**89 JOHN WHITEWAY DRIVE, GOSFORD (SSD-10321)
REQUEST FOR ADDITIONAL INFORMATION**

We refer to your letter requesting additional information dated 1 July 2021 in which the Department of Planning, Industry and Environment (the Department) has requested some additional information to inform the Department's assessment of the State Significant Development Application (SSD).

WATER VIEWS FOR UNITS NOT  
RECEIVING 3 HOURS OF SOLAR

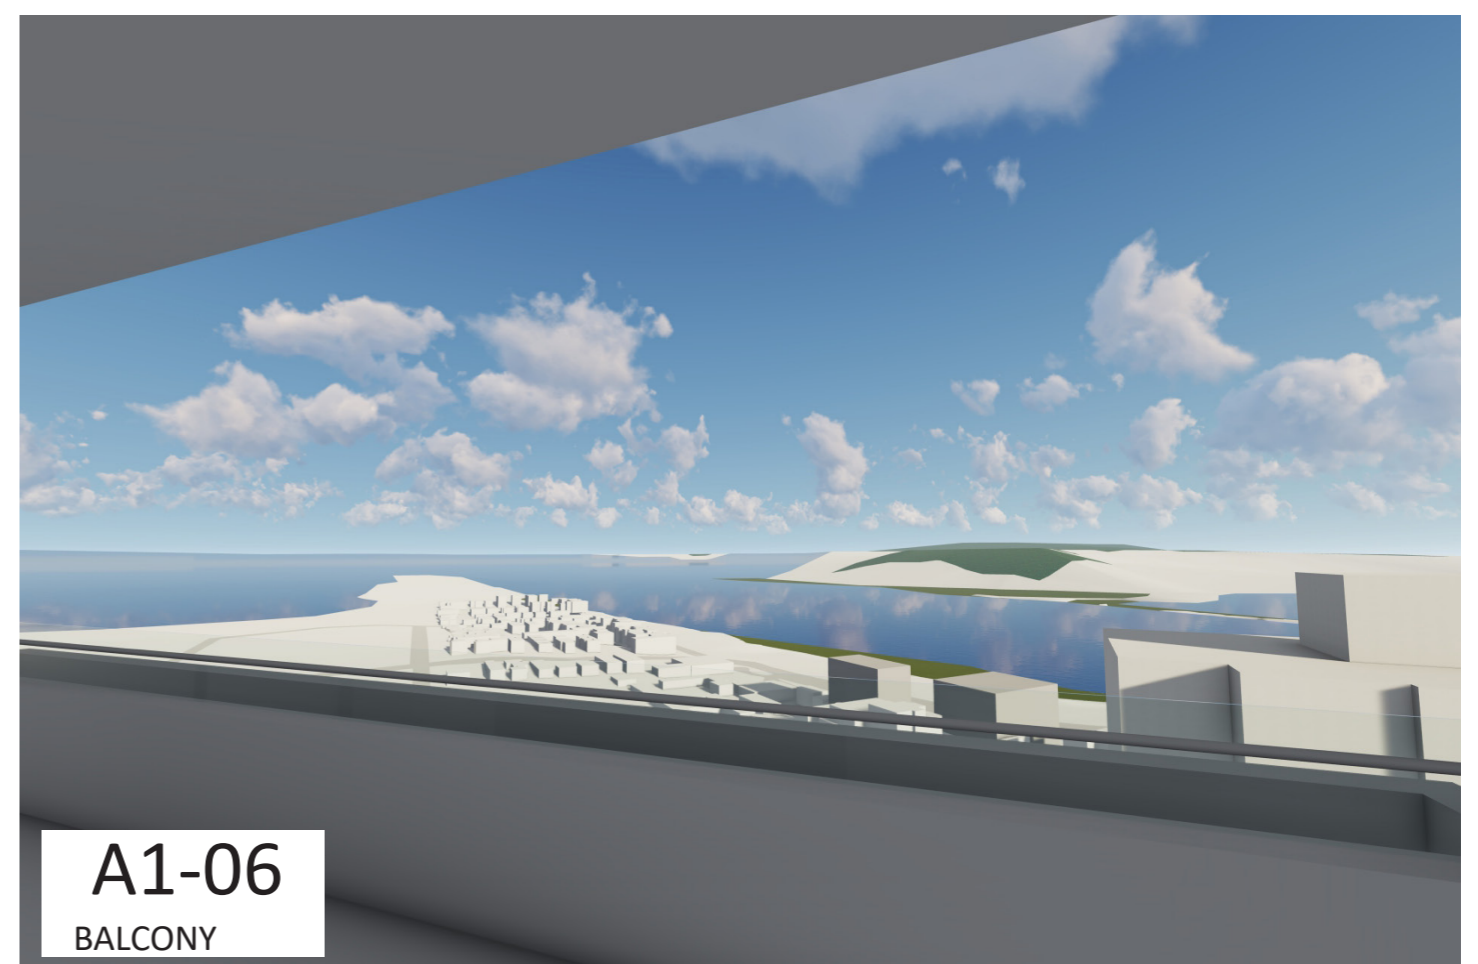
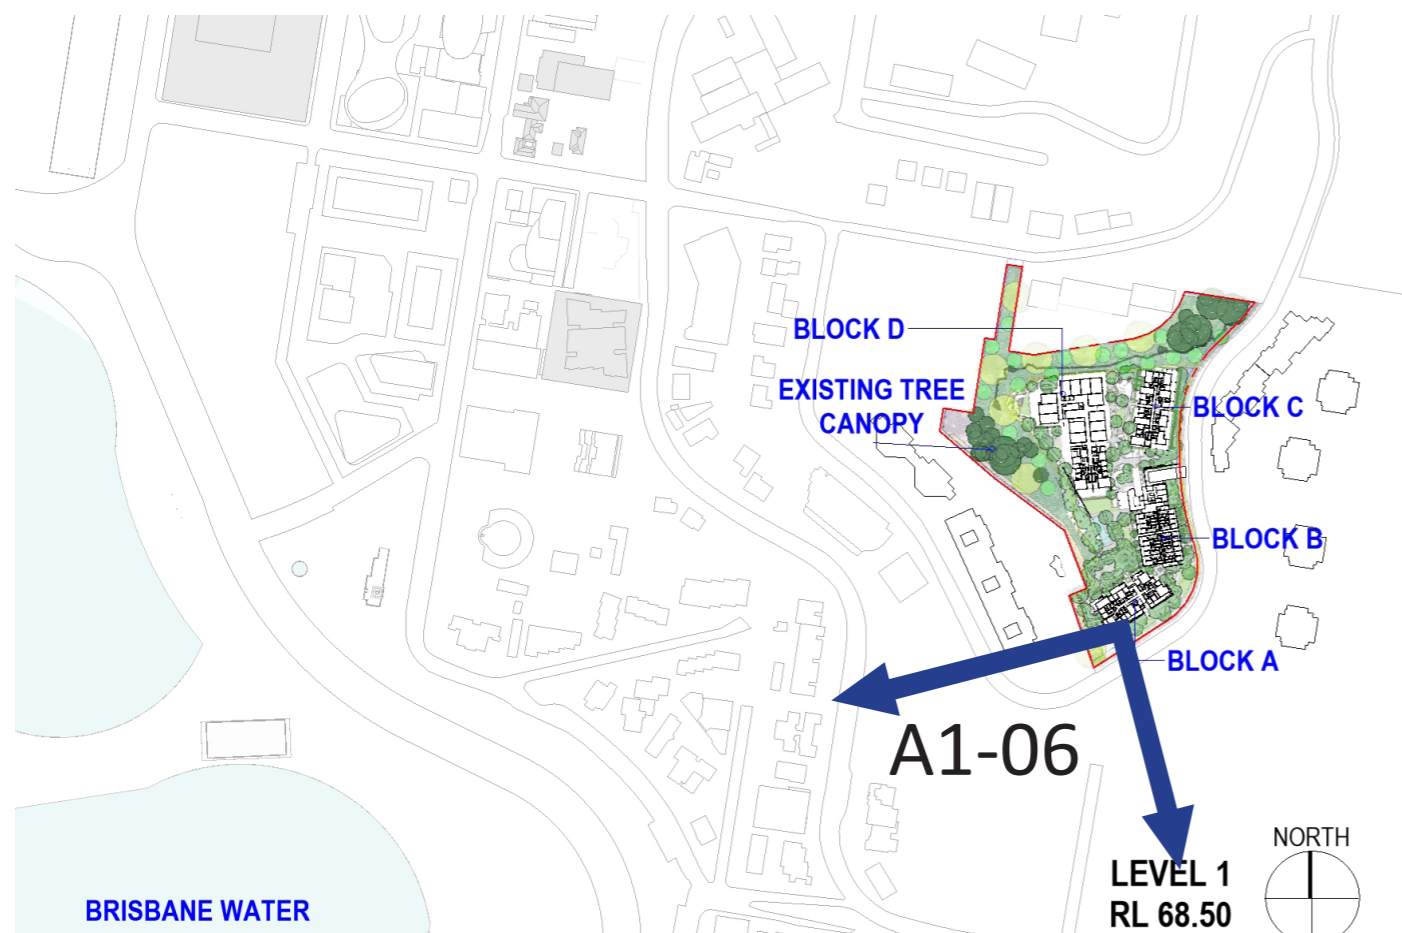
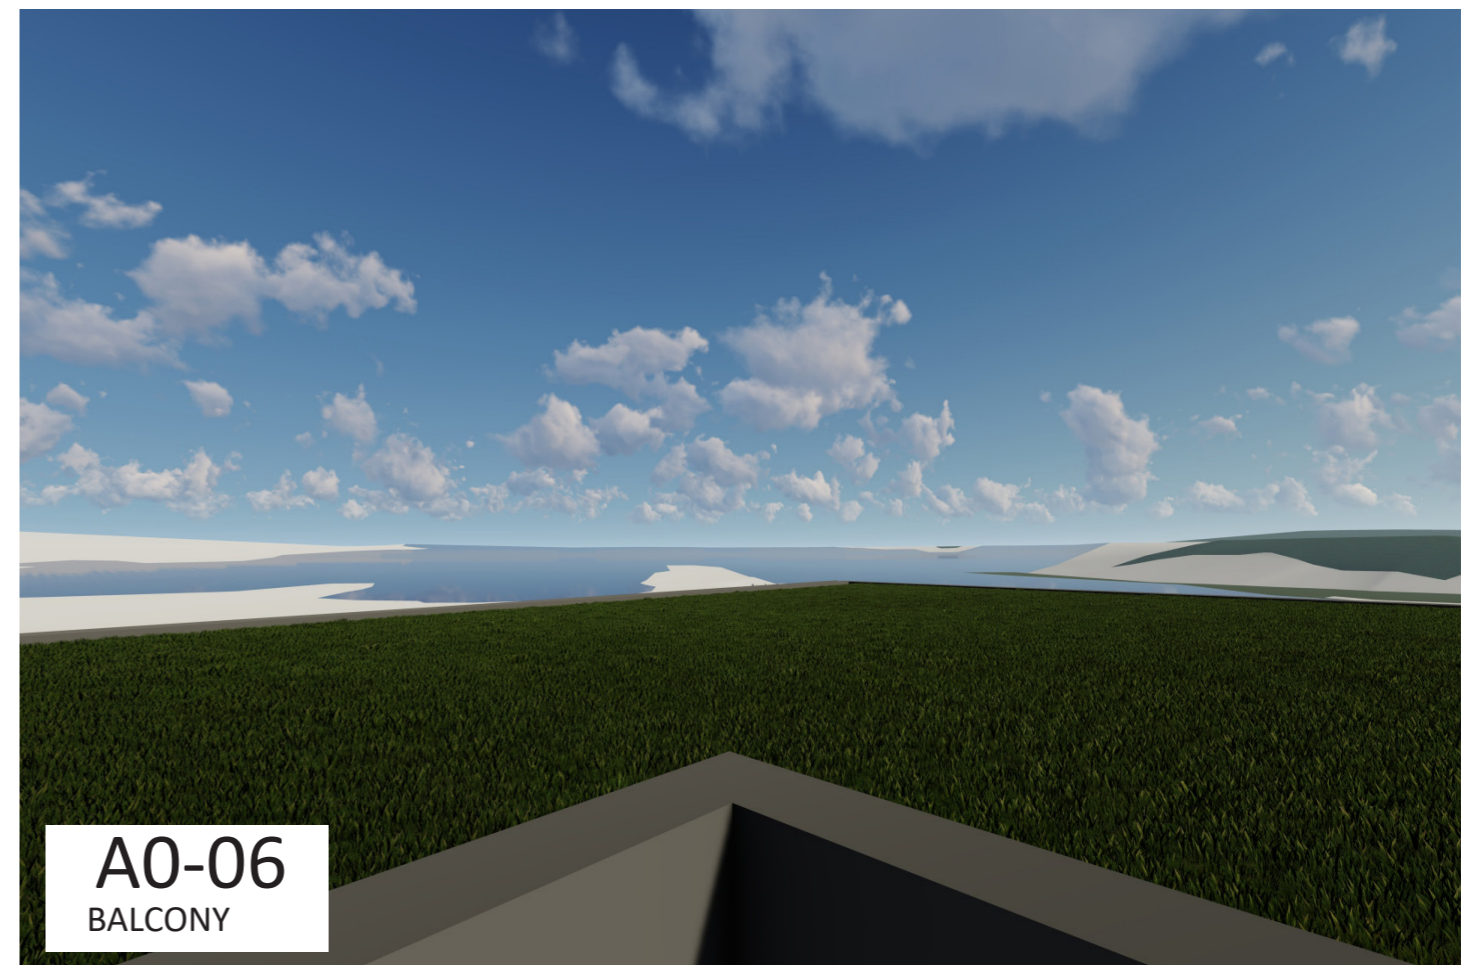
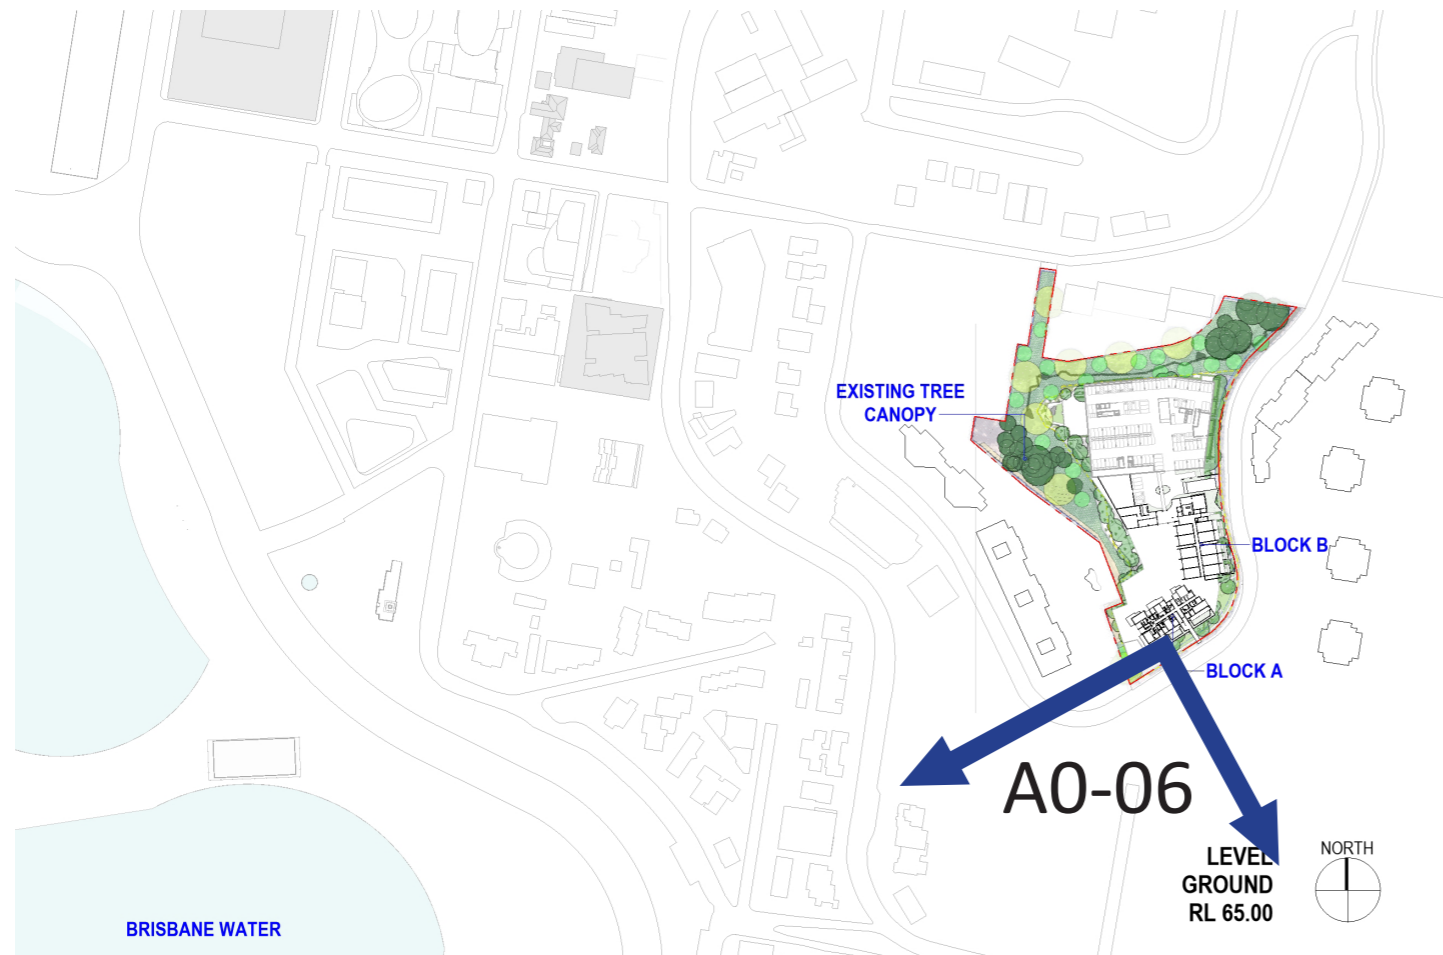
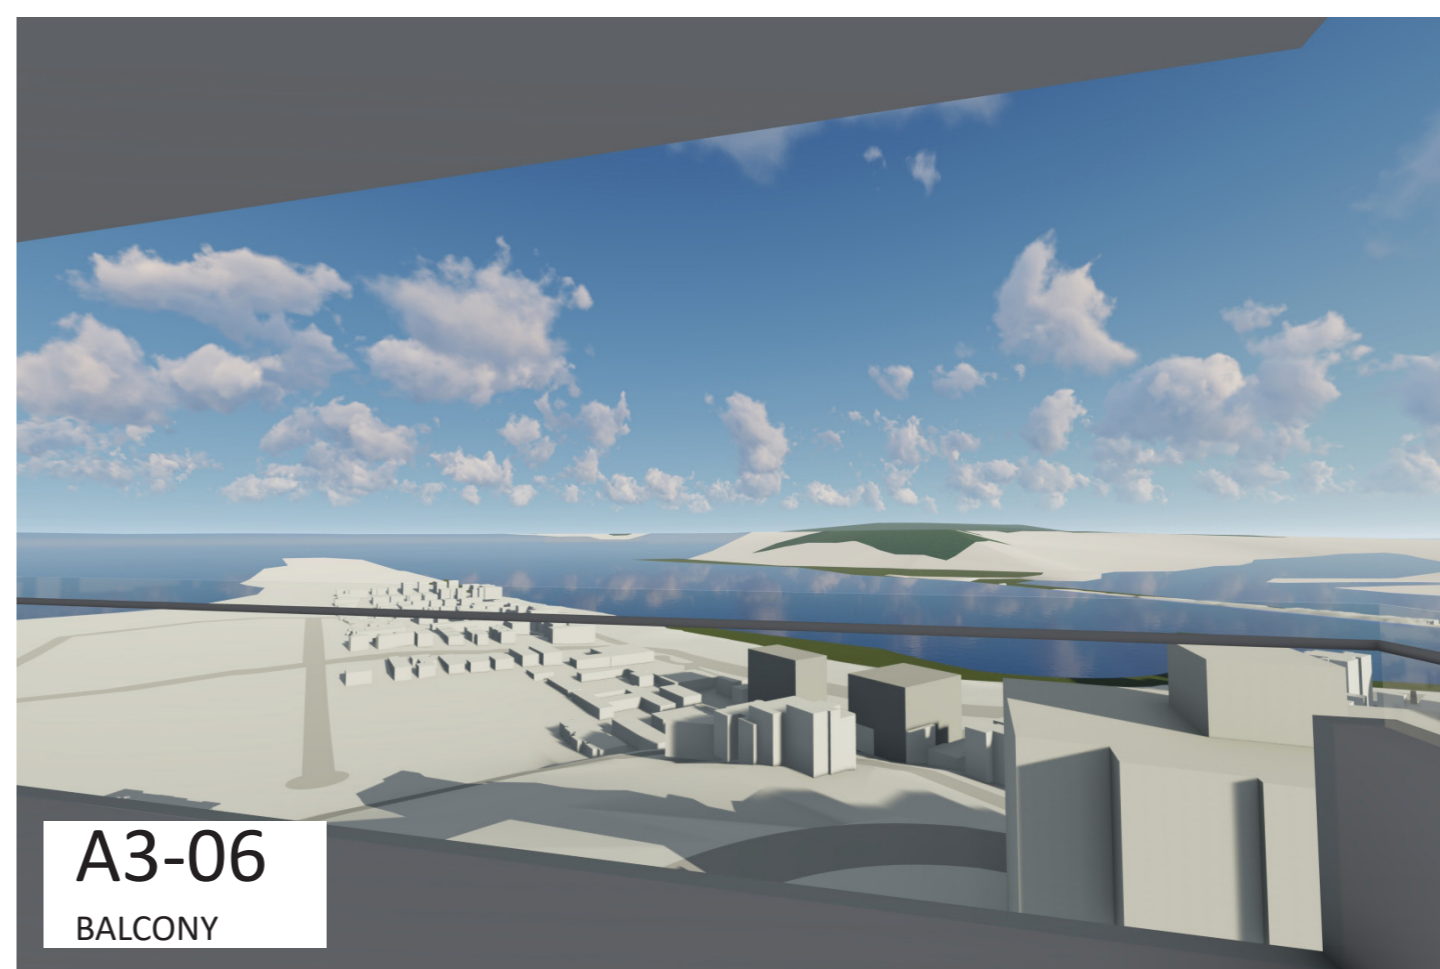
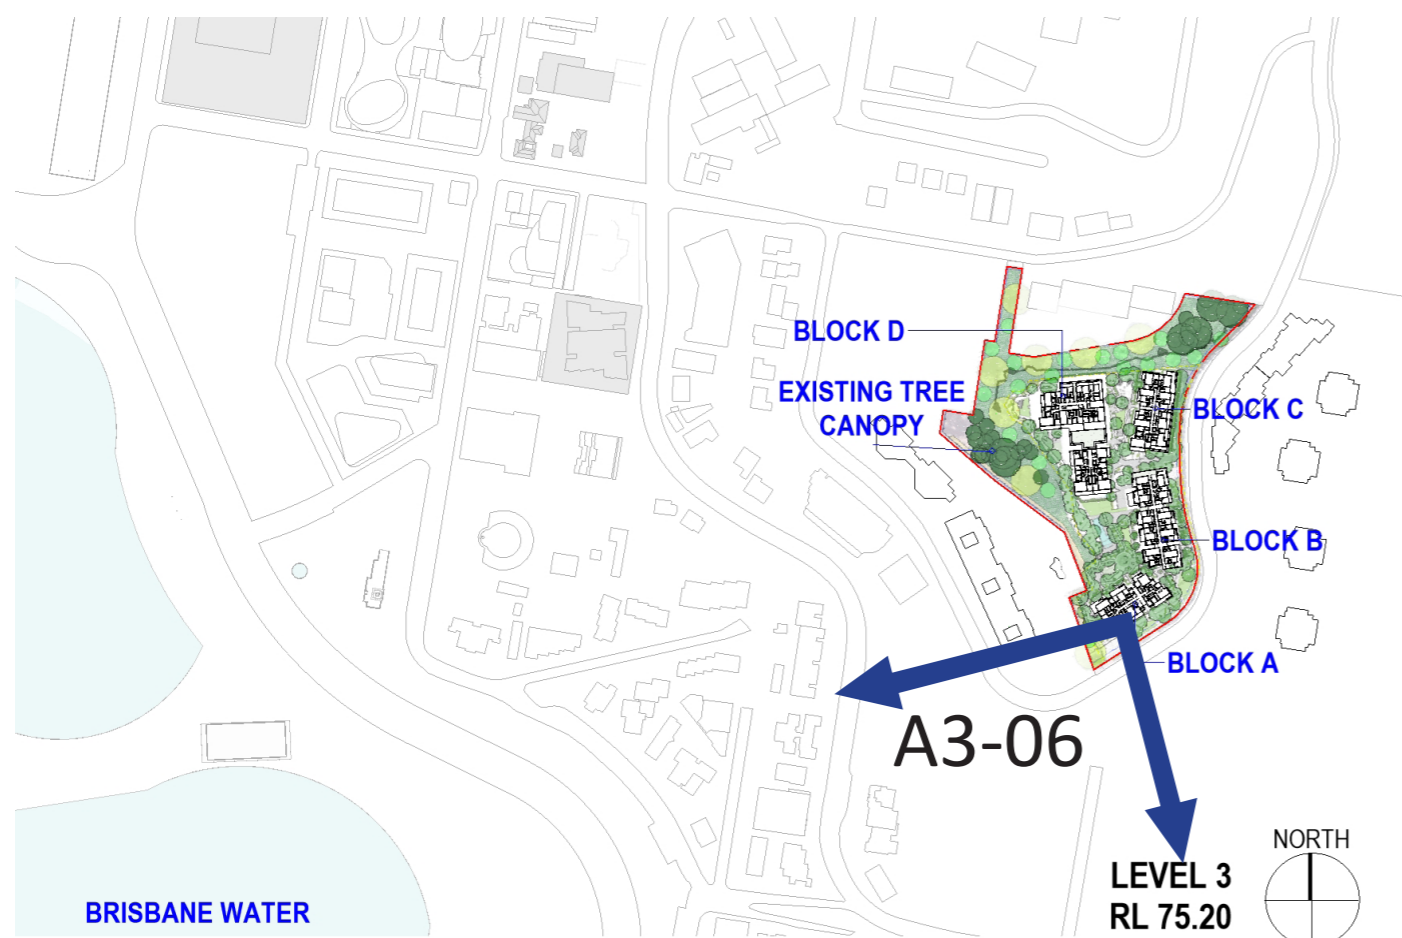
Comment	Response
Department of Planning, Infrastructure and Environment	
<p>Views The Amended DA and RtS nominates 40 units as receiving water views in order to justify flexibility in the solar access requirements under the Apartment Design Guide (ADG).</p> <p>It is unclear whether all of the nominated units actually receive significant water views. For example, the finished floor level of the nominated level 1 units is below the existing ground level along the western edge of the non-buildable boundary, therefore obstructing any views from these units.</p> <p>Further, there appears to be nominated units with an outlook obstructed by other buildings proposed on the site, or they face away from the water and would only benefit from less significant district views.</p> <p>Further information is required demonstrating primary view lines from living room and balcony areas to confirm these units benefit from significant water views, having regard to site topography, site levels and the proposed building layout.</p>	See Section 1.3 below.

ADG Architects have modelled each view of the units that do not achieve a minimum 3 hours solar access mid-winter but that have a water view (see **Appendix B**). The site is situated on a hill with views to the substantial Brisbane Water extent that broadly surrounds the site. While 48 units with less than 3 hours solar achieve a water view, the project has not included the view of unit D1-03 in the project's calculations. Accordingly, 47 units are identified in the model analysis. It is noted that a further 40 units also have water views that are not included in the analysis because they receive a minimum 3 hour solar access.

The modelled views identify the direction of view from each unit. Each unit view is generally taken from a central point of the balcony or terrace. The proposal is designed to feature indoor/outdoor living and has accordingly provided large covered outdoor living spaces as an extension to the indoor living spaces to enable year round enjoyment of the outdoors, including water views. Views from the primary living space would be largely similar to the model view as the living space is generally located off the balcony area.

This query has resulted in Unit D1-3 from being excluded from the view analysis to be conservative. It is clear from the model views that 47 units have water views and the Department should be satisfied that the existing Tree Canopy will not interrupt these.
